WEST SUSSEX COUNTY COUNCIL CONSULTATION

TO:	Arun District Council - FAO: Amber Willard
FROM:	WSCC – Highways Authority
DATE:	25 June 2026
LOCATION:	Plot 3 (not yet constructed) Fontwell Avenue Eastergate PO20 3RU
SUBJECT:	AL/46/26/S73 Variation of condition following the grant of AL/114/24/S73 relating to approved plans, vehicular access and pedestrian crossing and visibility splays
RECOMMENDATION:	More Information

Drawing Status		Planning	
Client			
Anna-Marie Ferrier			
Project			
Land West of Fontwell Avenue, Fontwell			
Drawing Title			
Access Overview & Visibility Splays			
Scale	Date	Drawn by	Checked by
As Shown	July 26	EMH	SMO
Drawing No.			Rev.
2026-6677-1002			A

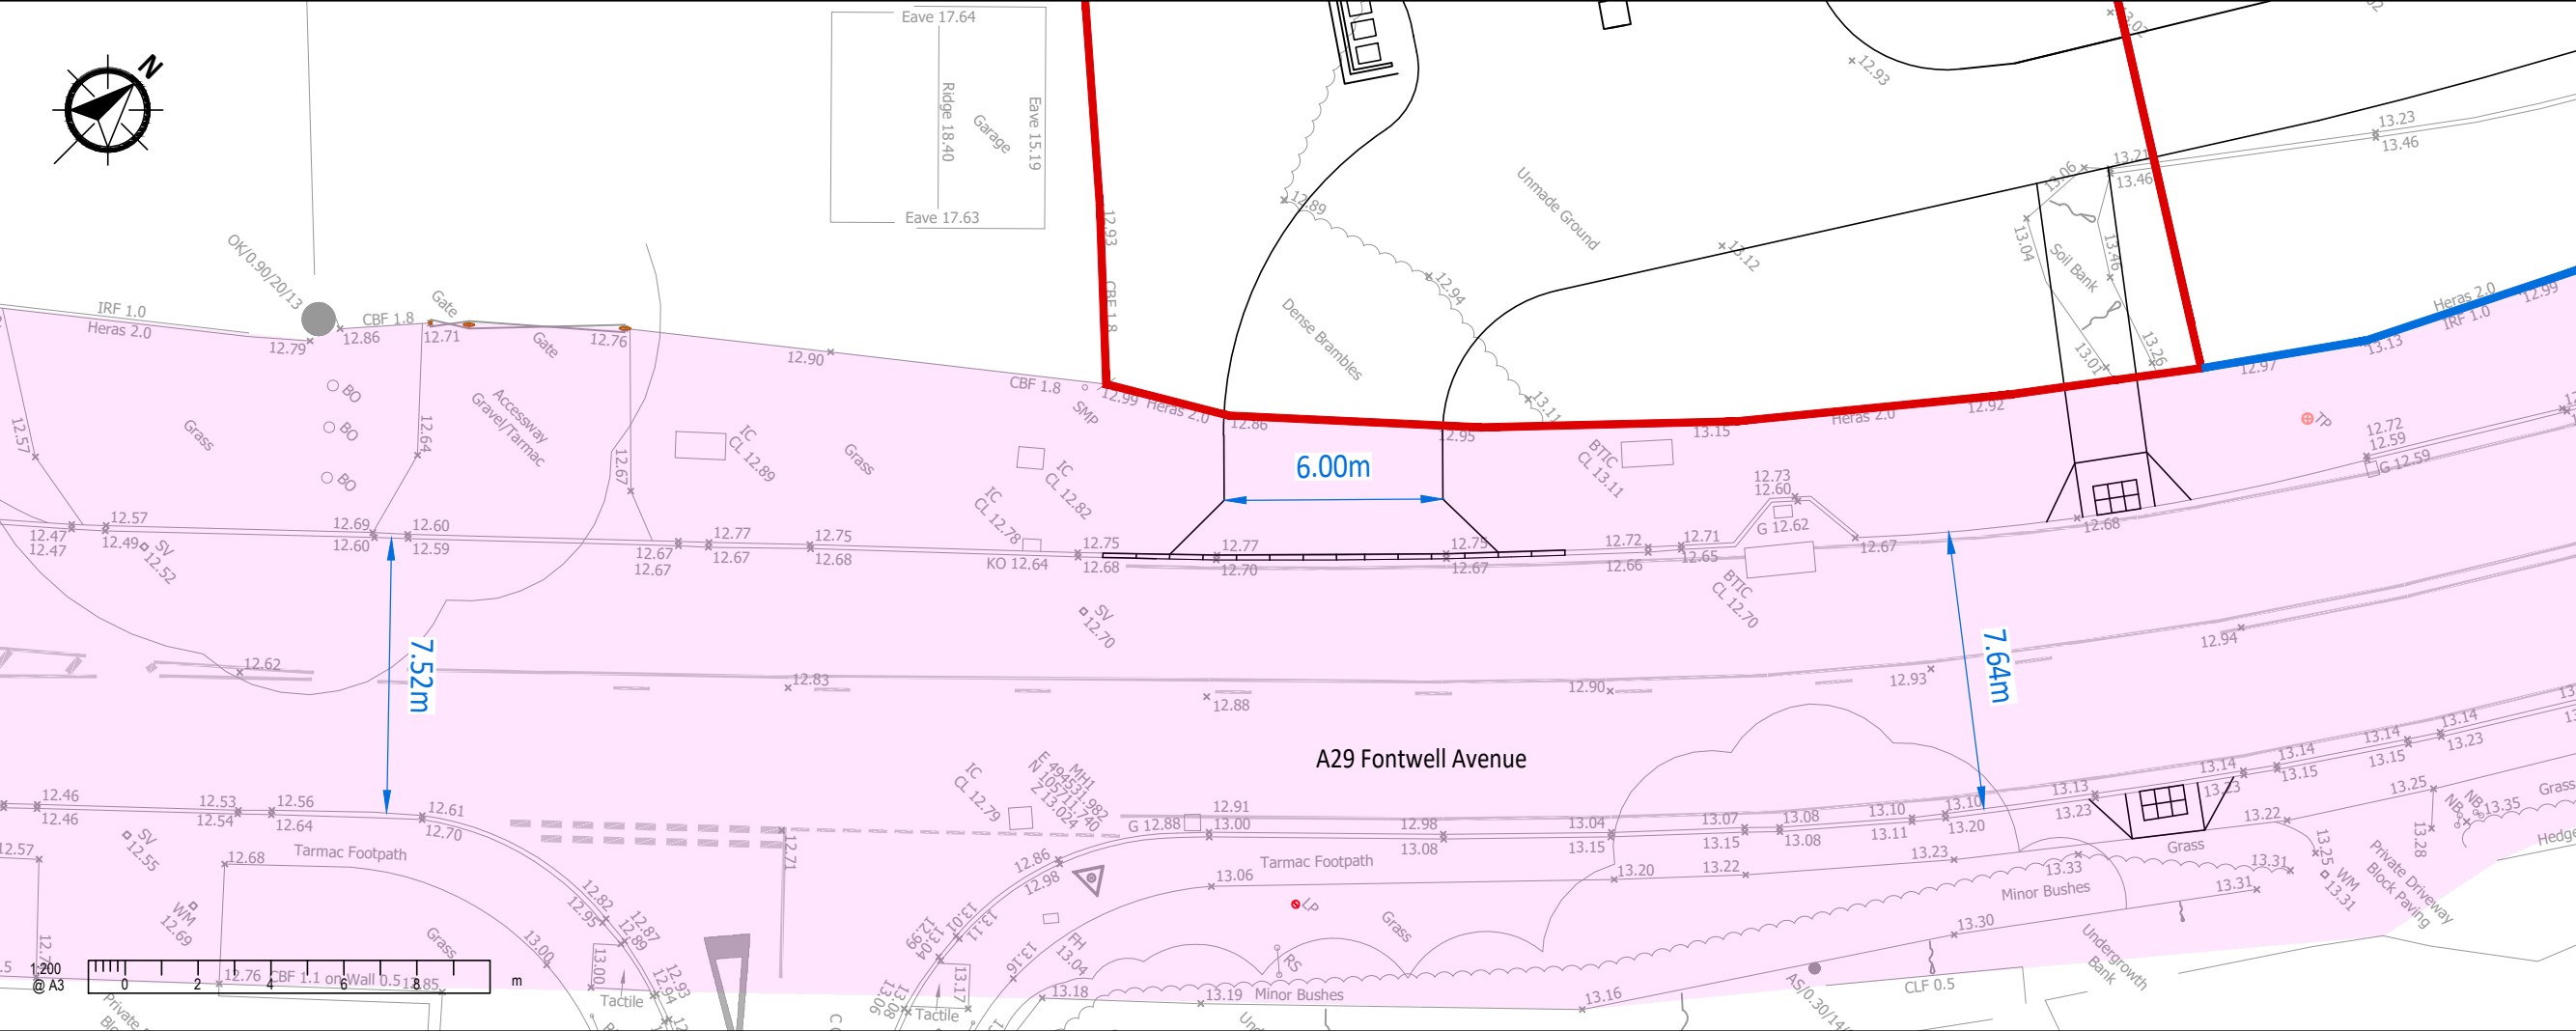
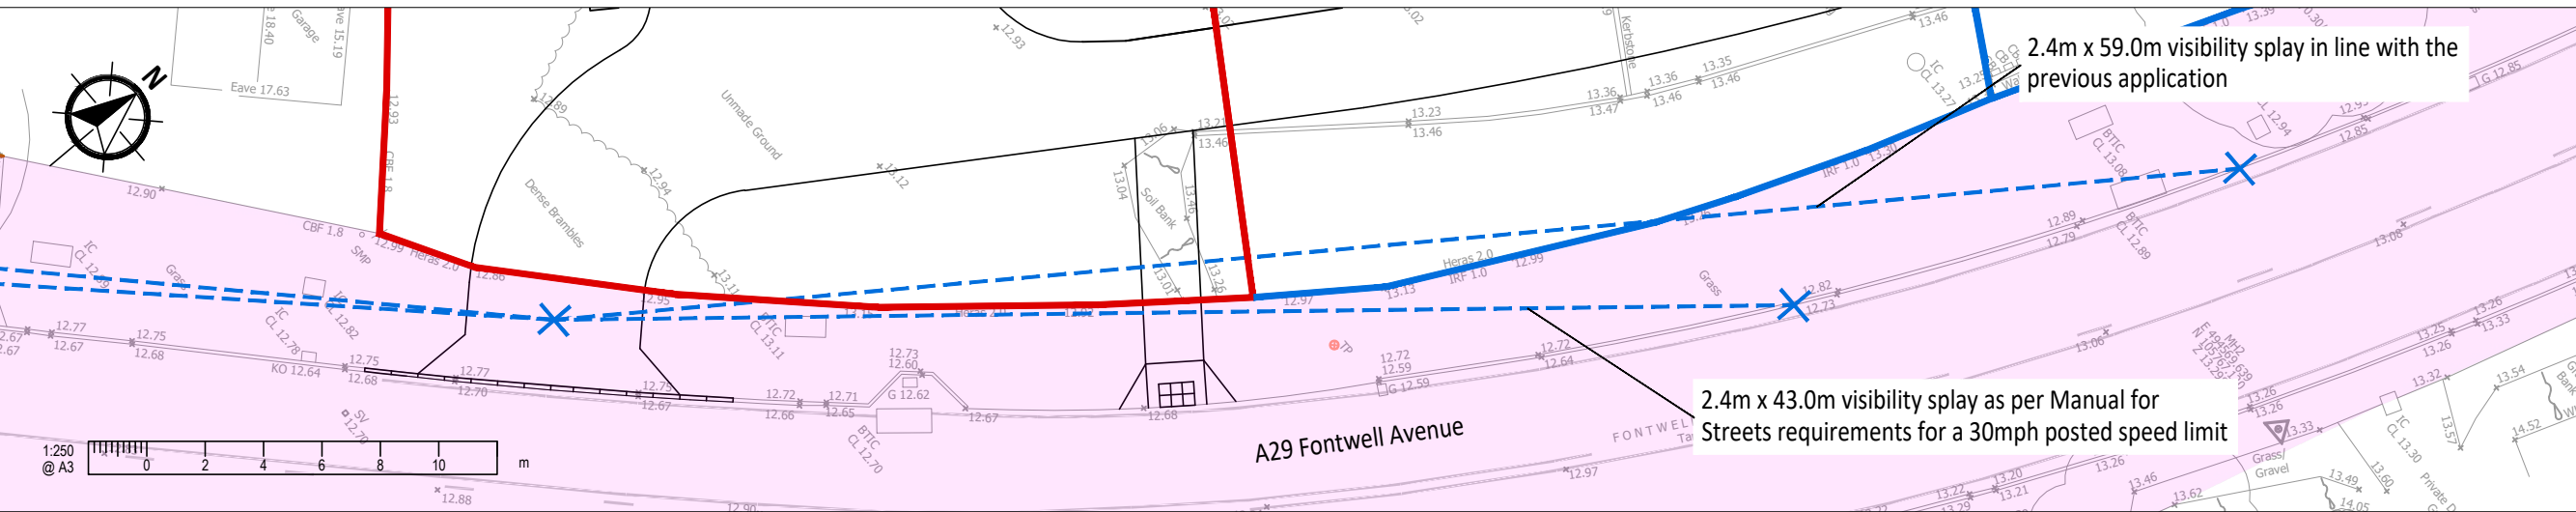
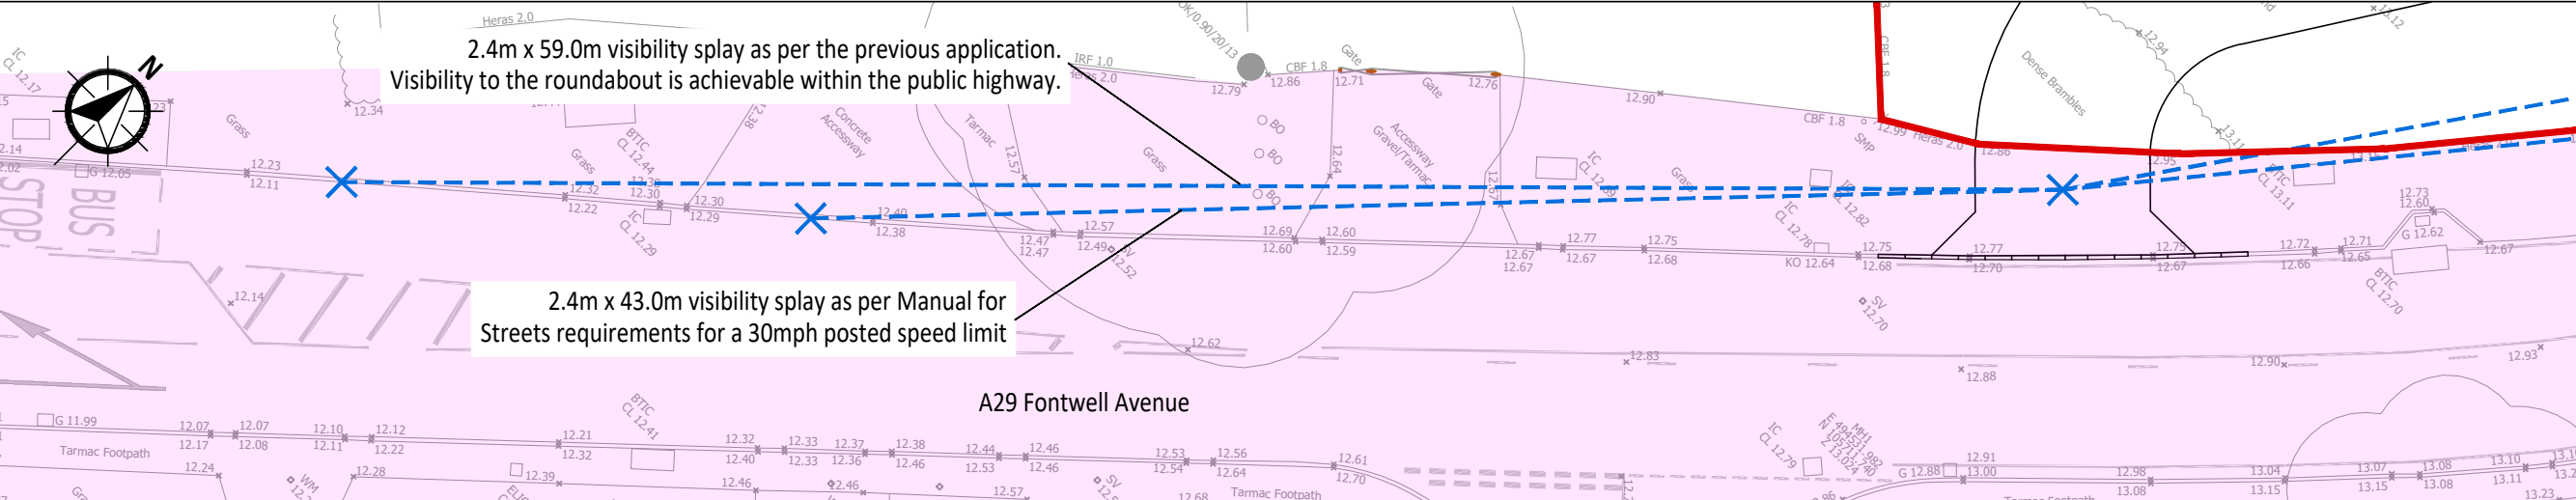
Vehicular visibility splays of 2.4m x 43m in accordance with 30mph speed limit have been demonstrated from the amended access location. In previous applications visibility splays of 59m had been provided and the Highways Statements states that splays in excess of 43m can be achieved. The LHA require clarification of the previous 59m splay as these were likely secured due to actual 85th percentile speeds. Whilst it is acknowledged that the posted limit is now 30mph, it would be useful for maximum achievable splays (within publicly maintained highway and applicant land) to be provided whilst being mindful of any impact a greater splay may have on landscaping on site frontage.

Please ask applicant for visibility splay clarifications/amendments and re-consult.
